## RE: Winkels Short Plat (SP-07-144)

The Kittitas County Community Development Services Department has determined that the Winkels Short Plat (SP-07-144) is a complete application and hereby grants **conditional preliminary approval** subject to the following conditions:

TO: Trudie Pettit, Staff Planner, Community Development Services  
FROM: Randy Carbery, Planner II *rc*  
DATE: November 26, 2007  
SUBJECT: Winkels Short Plat

**WINKELS SHORT PLAT
PART OF SECTION 23, T. 17 N., R. 18 E., W.M.
KITTITAS COUNTY, WASHINGTON**

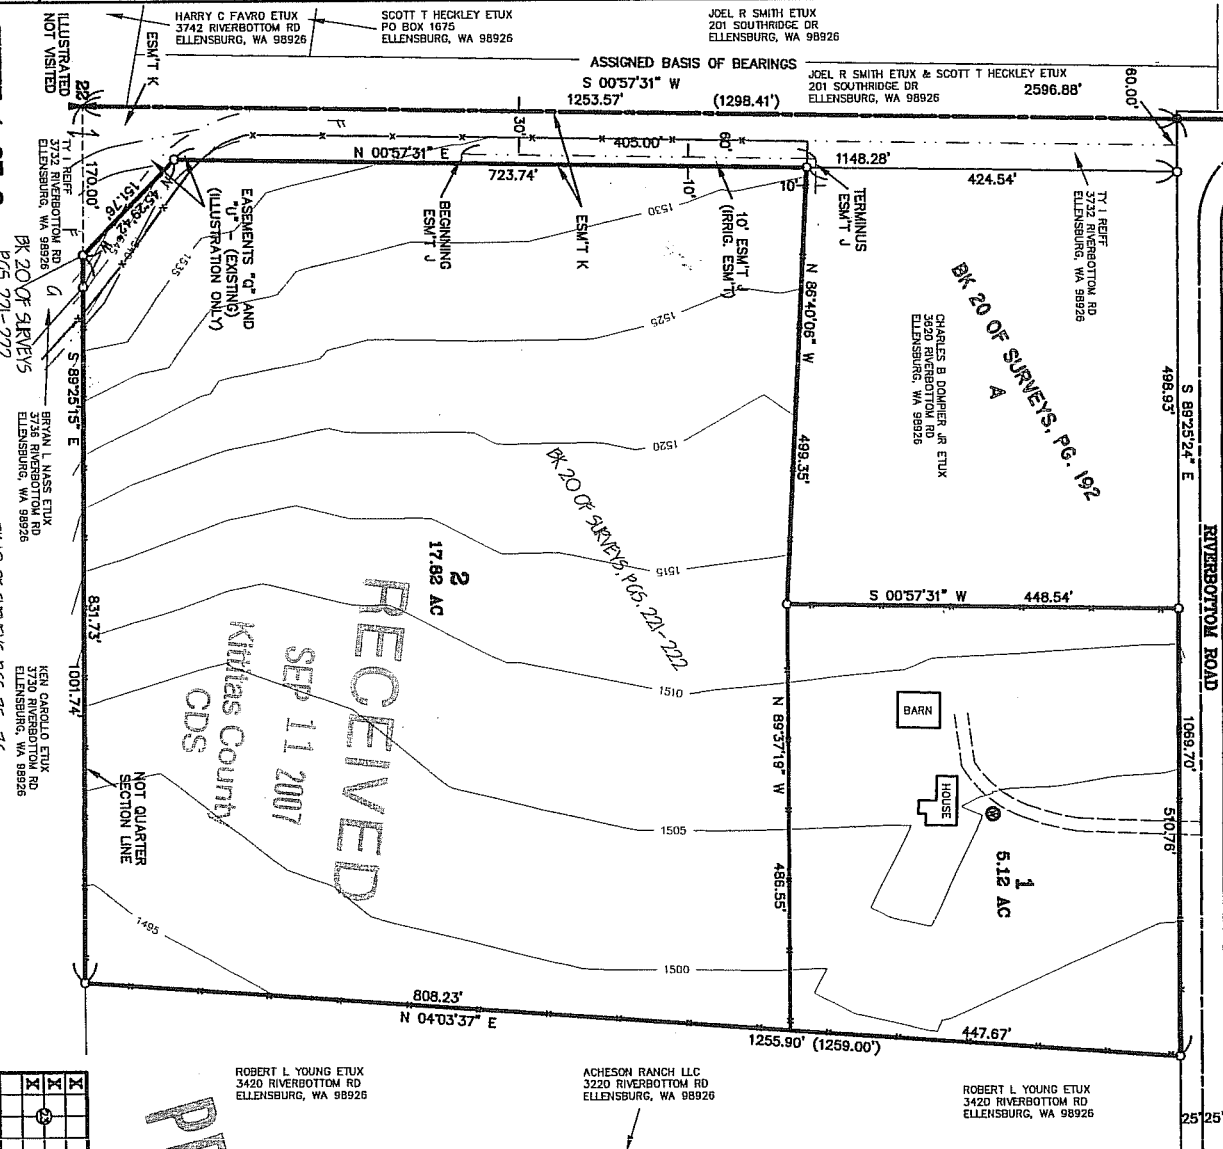
1. Access Spacing Requirement: Riverbottom Road is classified as a Rural Local Collector. Current Kittitas County Road Standards require a minimum 100' spacing between access locations. The proposed access to lot 2 does not meet current Kittitas County Road Standards for access spacing. The lots currently being served by this access easement were created through exempt segregations which were not reviewed by our department for compliance with current Kittitas County Road Standards at the time they were created.

2. Access: Access to lot 2 shall be from Riverbottom Road, thru lot 1. A minimum 20' wide access easement shall be required. Access may be via the existing driveway or via a separate access easement across lot 1. Any new access shall meet or exceed the 100' minimum access spacing requirement.

- 5. Plat Notes: Plat note #10 shall be removed from the final plat.
- 6. Lot Closure: It is the responsibility of the Professional Licensed Surveyor (PLS) to ensure the lot closures are correct and accurate.
